CITY OF ALBUQUERQUE

March 15, 2022

Re: Champion Xpress
2100 Central Ave. SW
Traffic Circulation Layout
Architect's Stamp XX-XX-XX (J13-D216)

PROJECT TITLE	CHAMPION XPRESS CARWASH
PROJECT MANAGER	2100 CENTRAL AVE, ALBUQUERQUE, NM 87104
JOB NO.	DRAWN BY:
PROJECT NUMBER	
SHEET TITLE	ARCHITECTURAL SITE PLAN

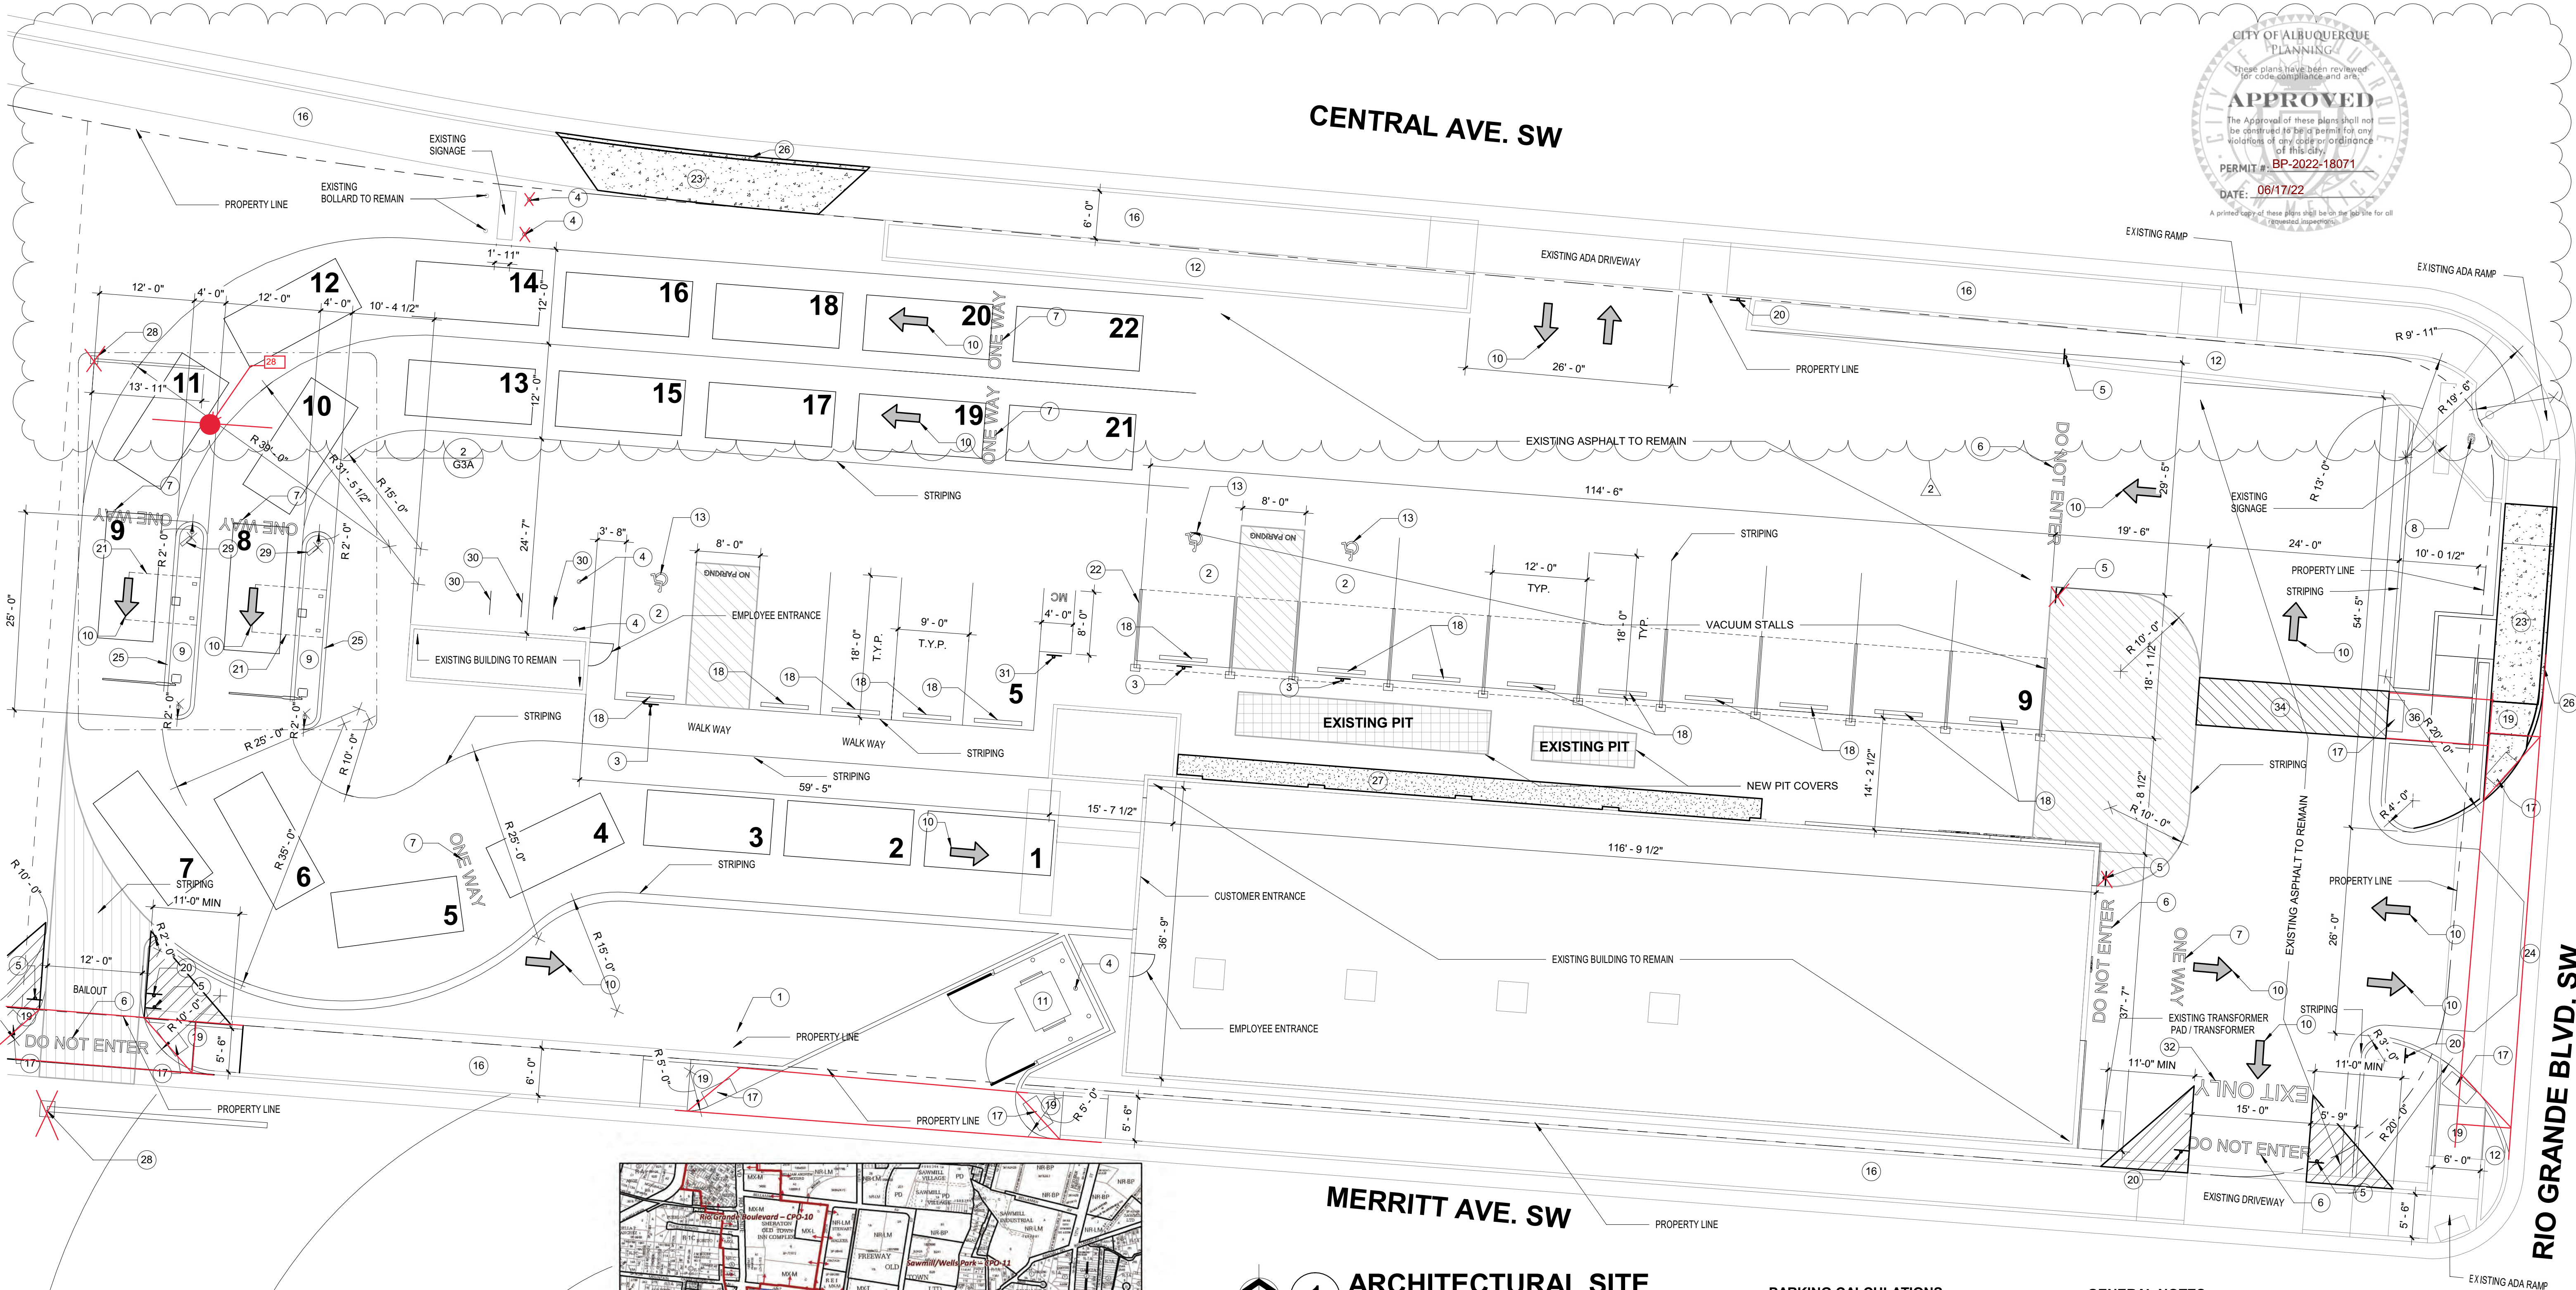
1. Please show a vicinity map showing the location of the development in relation to streets and well known landmarks.
2. List the number of parking spaces required by the IDO as well as the proposed number of parking spaces including bicycle and motorcycle parking.
3. The traffic circulation layout must be stamped, signed, and dated by an engineer or architect licensed in the state of New Mexico.
4. Identify all existing access easements and rights of way width dimensions.
5. Identify the right of way width, medians, curb cuts, and street widths on Central Ave., Rio Grande Blvd. and Merritt Ave.
6. Clarify existing property lines and proposed property lines.
7. Curb Return Access is recommended on Central Ave.
8. All existing drivepads need to be ADA accessible. Please updated them to current standard.
9. Maximum access width for arterial, collector, and local streets are as follows:

10. Existing ramp at the corner of Rio Grande Blvd and Merritt Ave need to be updated to current ADA standard.
11. Provide the width for the existing sidewalk.

12. Provide dimensions and "Do Not Enter" sign for the BALOUT area.
13. Drive through facilities: Minimum 3 Vehicles stacking spaces shall be provided pursuant to Table 5-5-8 (Required Stacking spaces).
14. Provide ADA parking space
15. The minimum parking stall dimensions are:

25. Per the DPM, a 6 ft. wide ADA accessible pedestrian pathway is required from the public sidewalk to the building entrances. Please clearly show this pathway and provide details.

26. Per DPM, a 6 ft. wide ADA accessible pedestrian pathway is required from the ADA parking stall access aisles to the building entrances. Please clearly show this pathway and provide details.

27. ADA accessible pedestrian pathway should not be placed behind parking space or adjacent to a vehicular way. Vehicle and pedestrian/wheel chair conflicts should be avoided as much as possible.

28. All sidewalks along streets should be placed at the property line.
29. Provide a copy of Fire Marshal Approval.
30. It is not apparent what type of pavement surface is being proposed. A hard driving surface will be required as part of this proposed project for parking area and drive aisles.

31. All one-way drives shall have "One Way" signage. Please show detail and location of posted signs.
32. Provide "DO NOT ENTER" and "EXIT ONLY" signage for the existing drivepad off Merritt Ave.

33. Show the Intersection Sight Distance for Central Ave. and Rio Grande Blvd. and add the following note to the plan: "Landscaping and signage will not interfere with clear sight requirements. Therefore, signs, walls, trees, and shrubbery between 3 and 8 feet tall (as measured from the gutter pan) will not be acceptable in the clear sight triangle.

34. Show the clear sight triangle for Merritt Ave. and add the following note to the plan: "Landscaping and signage will not interfere with clear sight requirements. Therefore, signs, walls, trees, and shrubbery between 3 and 8 feet tall (as measured from the gutter pan) will not be acceptable in the clear sight triangle.

DATE 04/25/2022	SHEET G6
SCALE:

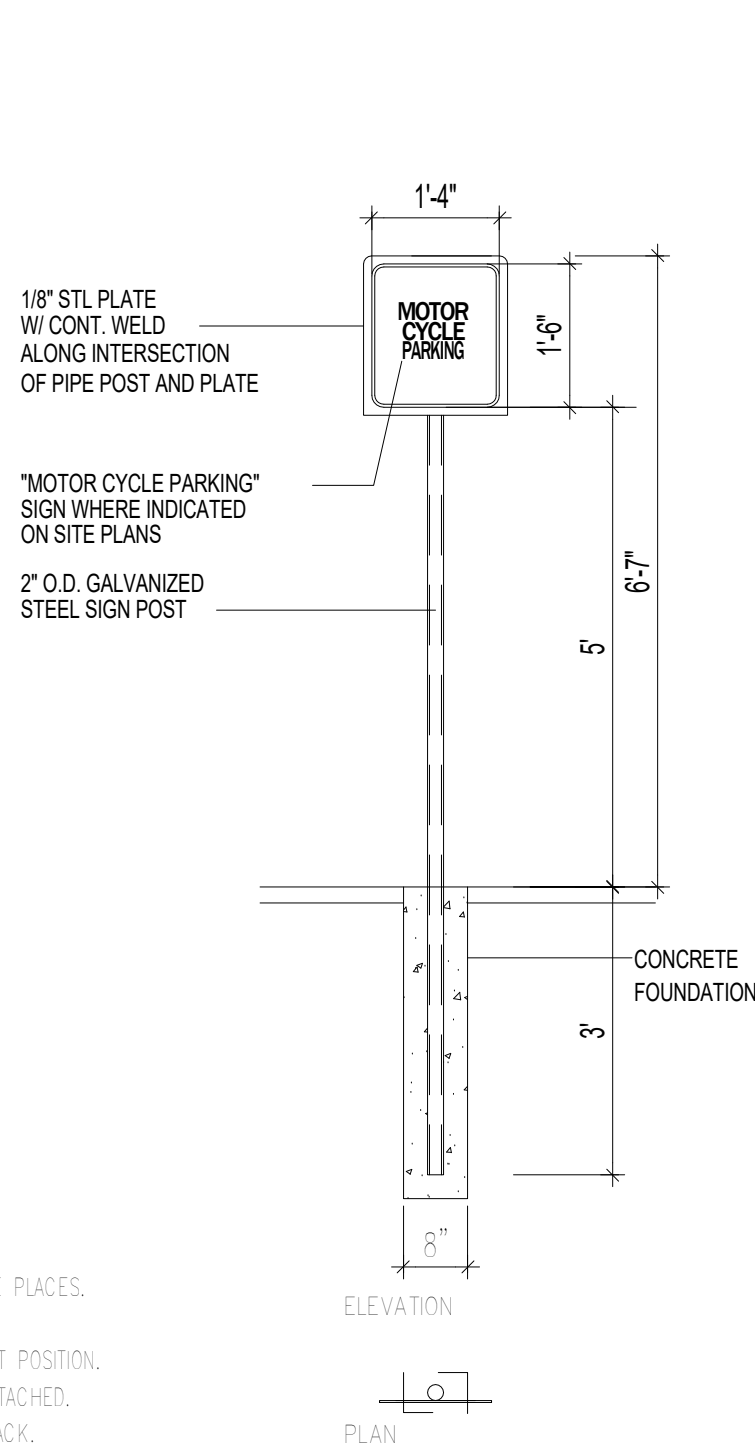
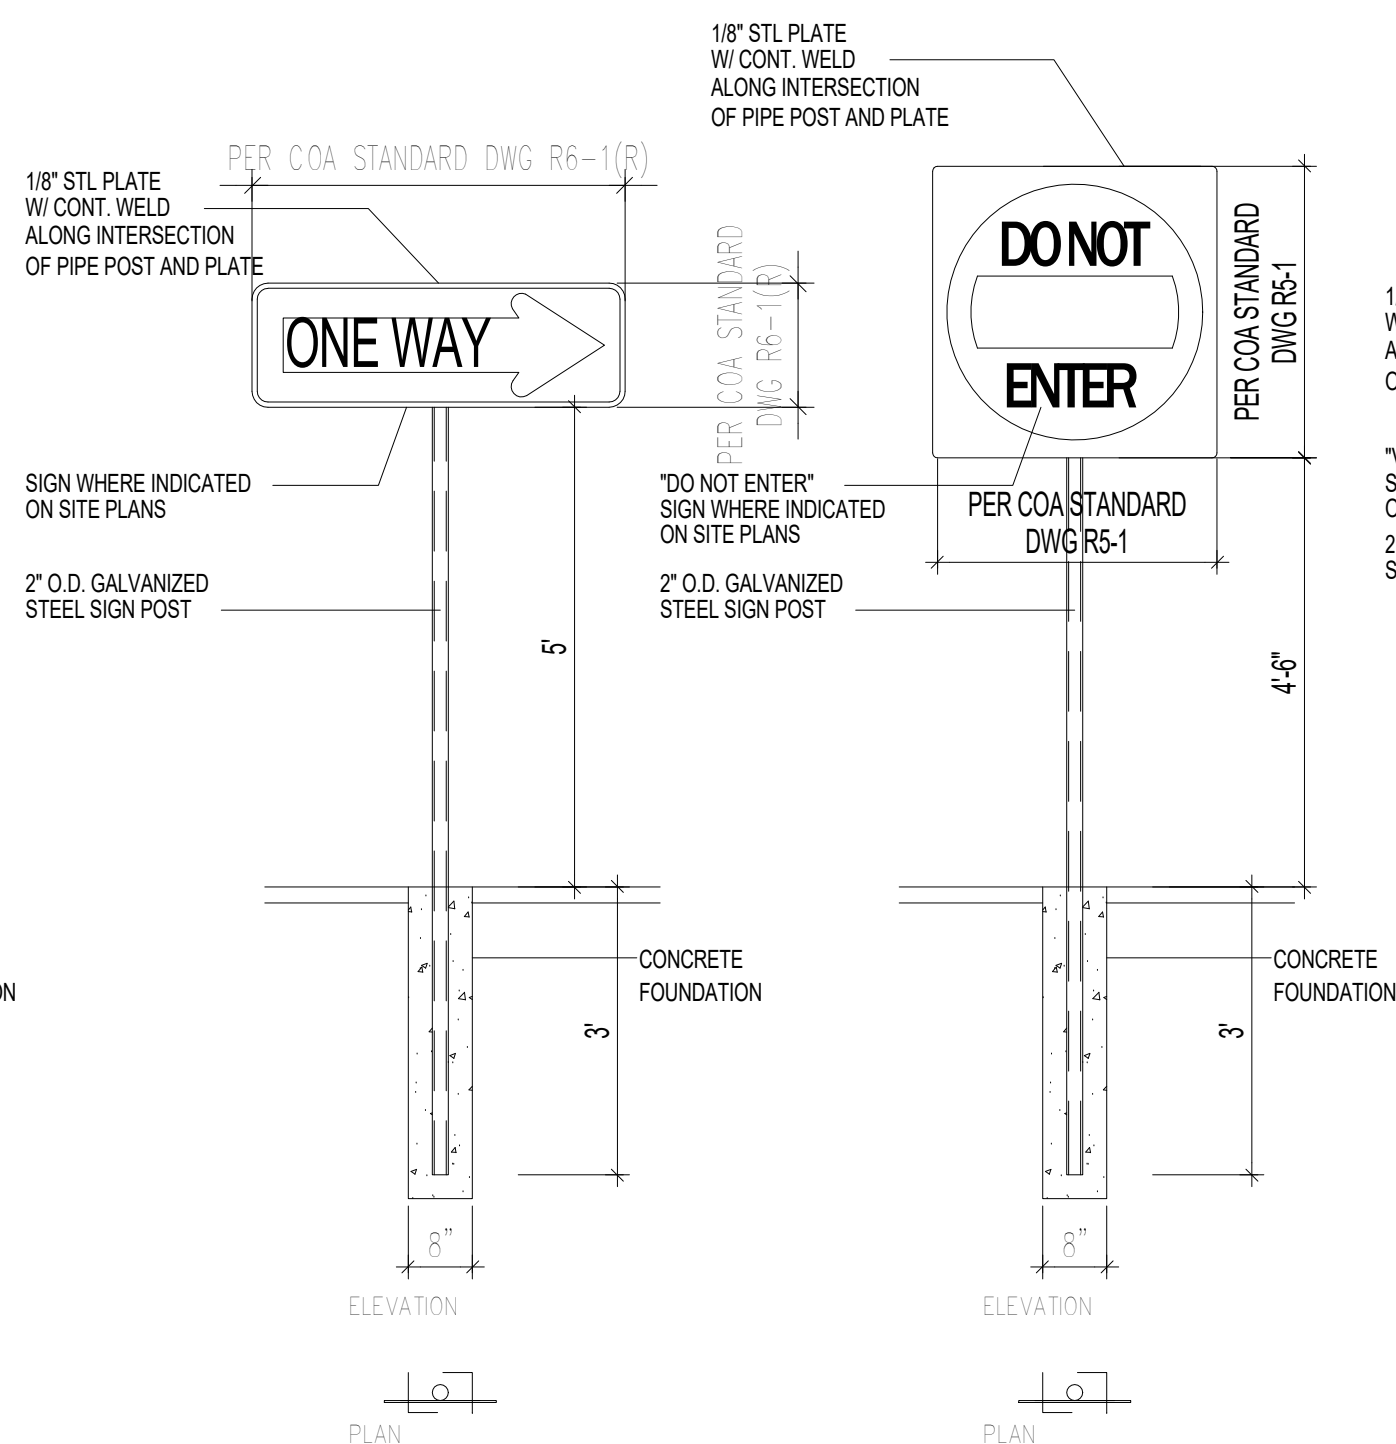
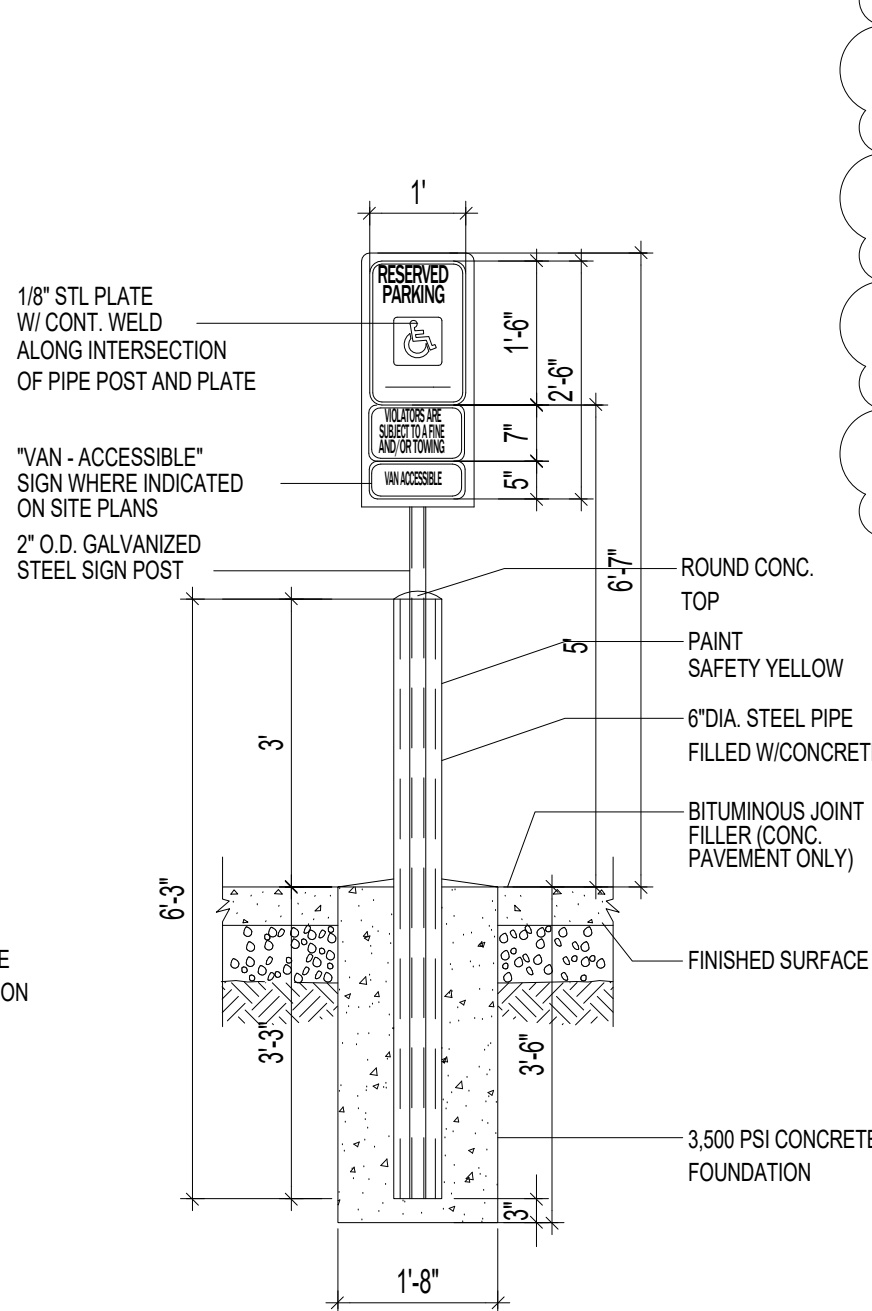
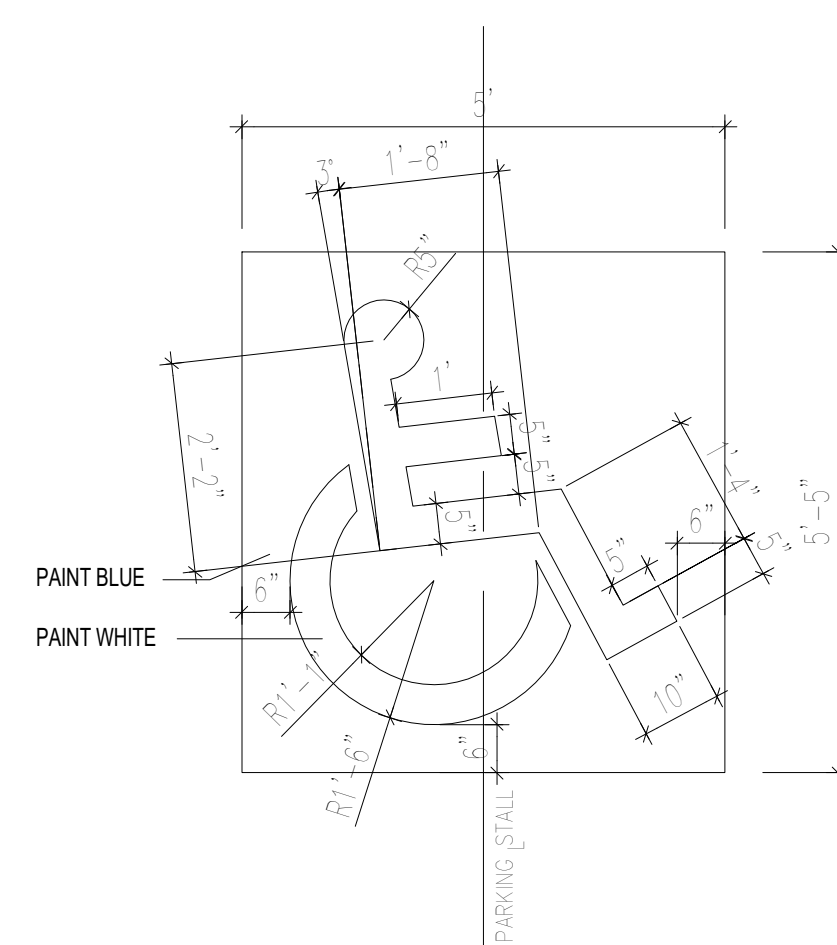
16. The ADA accessible spaces must include an access aisle. Van accessible aisles should be 8ft wide; all others should be 5ft wide.
17. The ADA accessible parking sign must have the required language per 66-7-352.4C NMSA 1978 "**Violators Are Subject to a Fine and/or Towing.**" Please call out detail and location of signs.

- c. The rack shall be designed to support the bicycle in an upright position. See the IDO for additional information.
 - d. The rack allows varying bicycle frame sizes and styles to be attached.
